Application No: BR/83/22/PL
Site Address: Unit 10 Arun Business Park Shripney Road Bognor Regis PO22 9SX
Description of works: Addition of two first floor windows at rear of property. This application is in CIL Zone 4 (Zero Rated) as other development.

Thank you for your internet representation made on 7th May 2022 which has been recorded as an objection with the comments as follows:

Drawing Ref. 2193SL
Revision B
Drawn CH

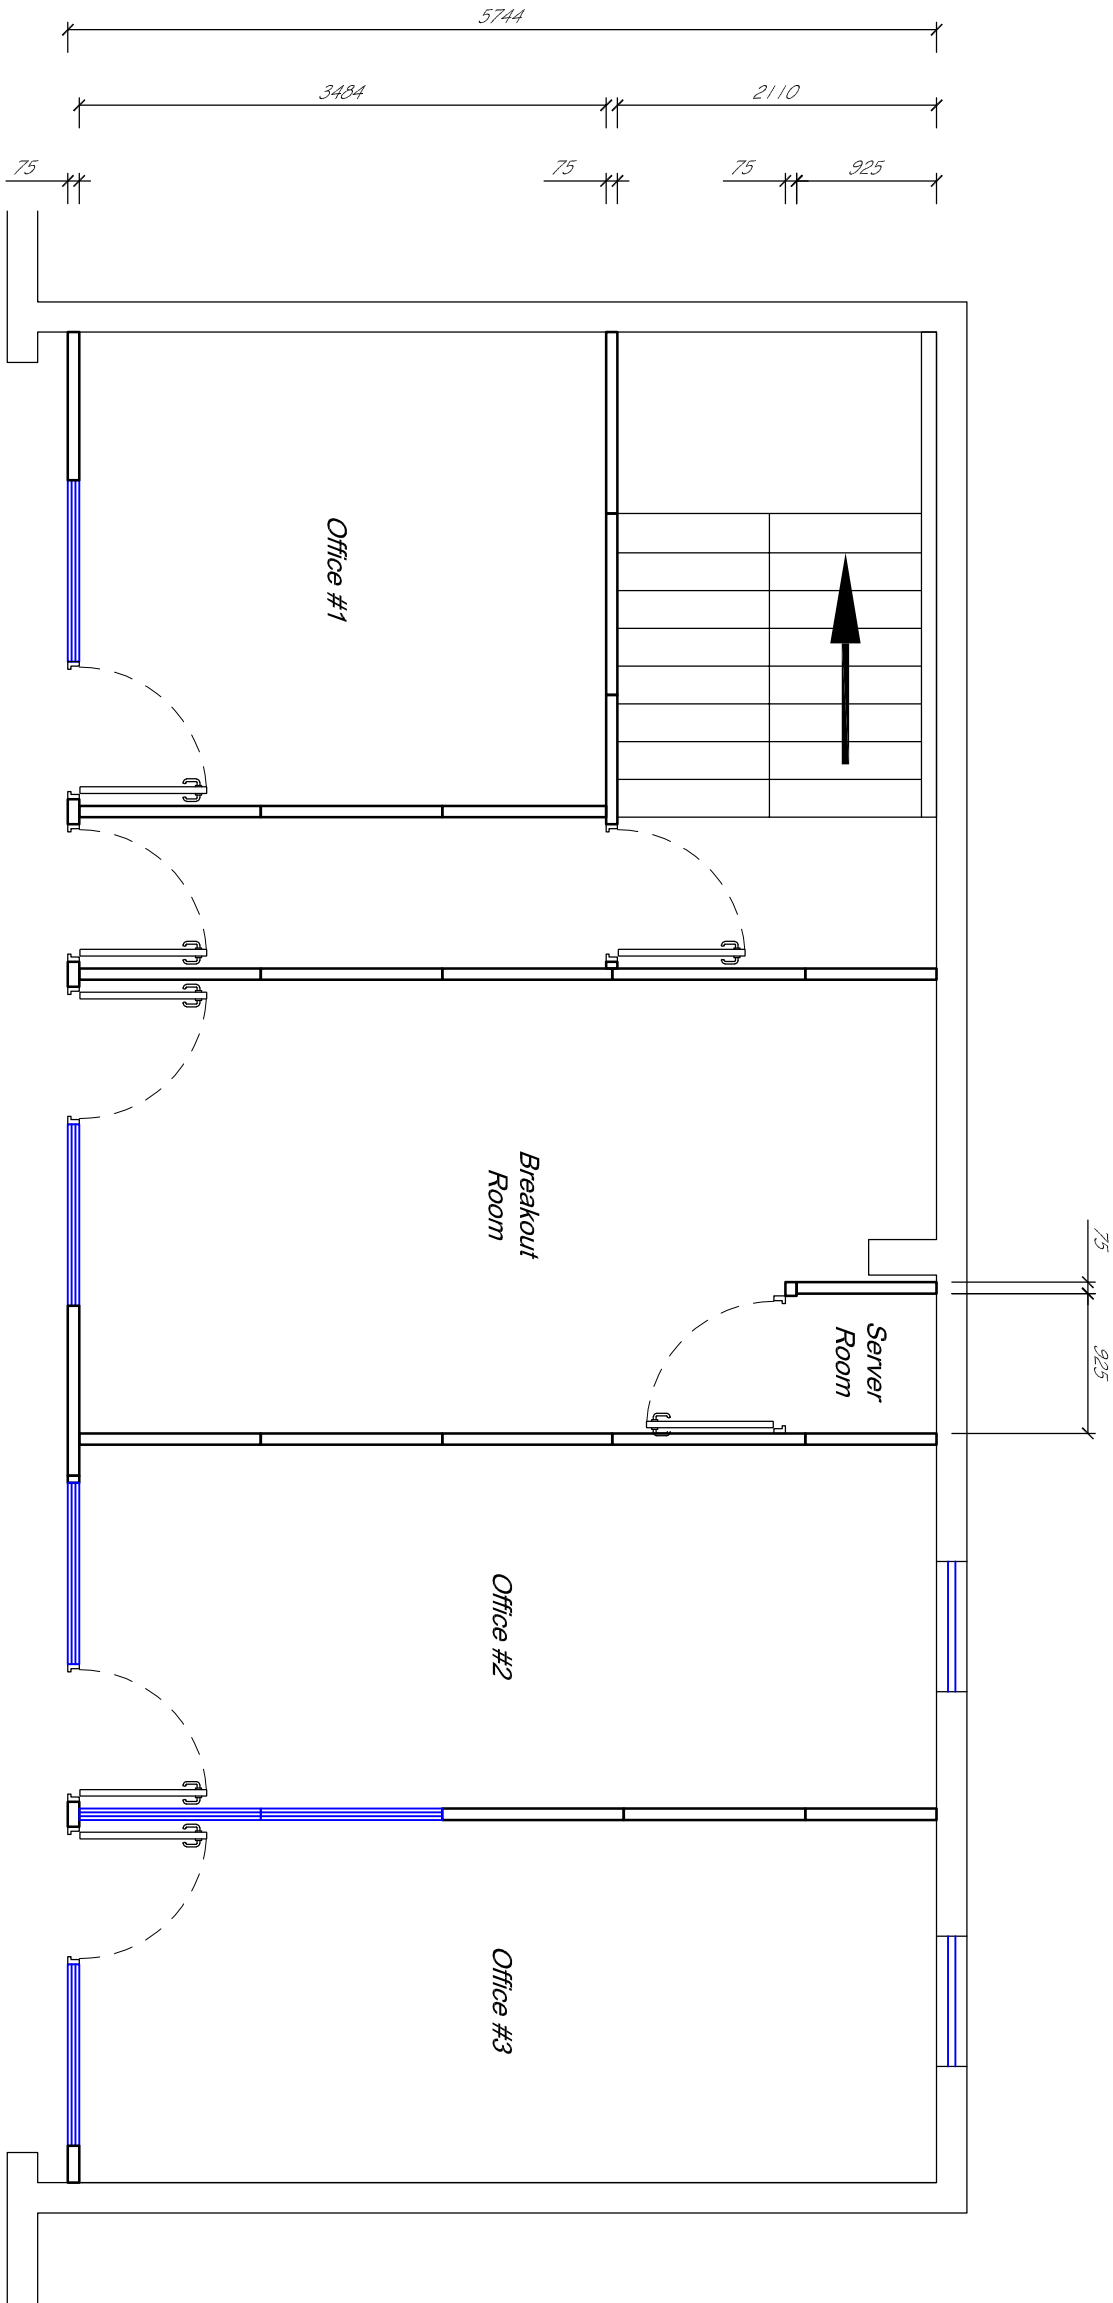
Object proposal for new windows looking over my garden into bedroom and bathroom. I have three young children.
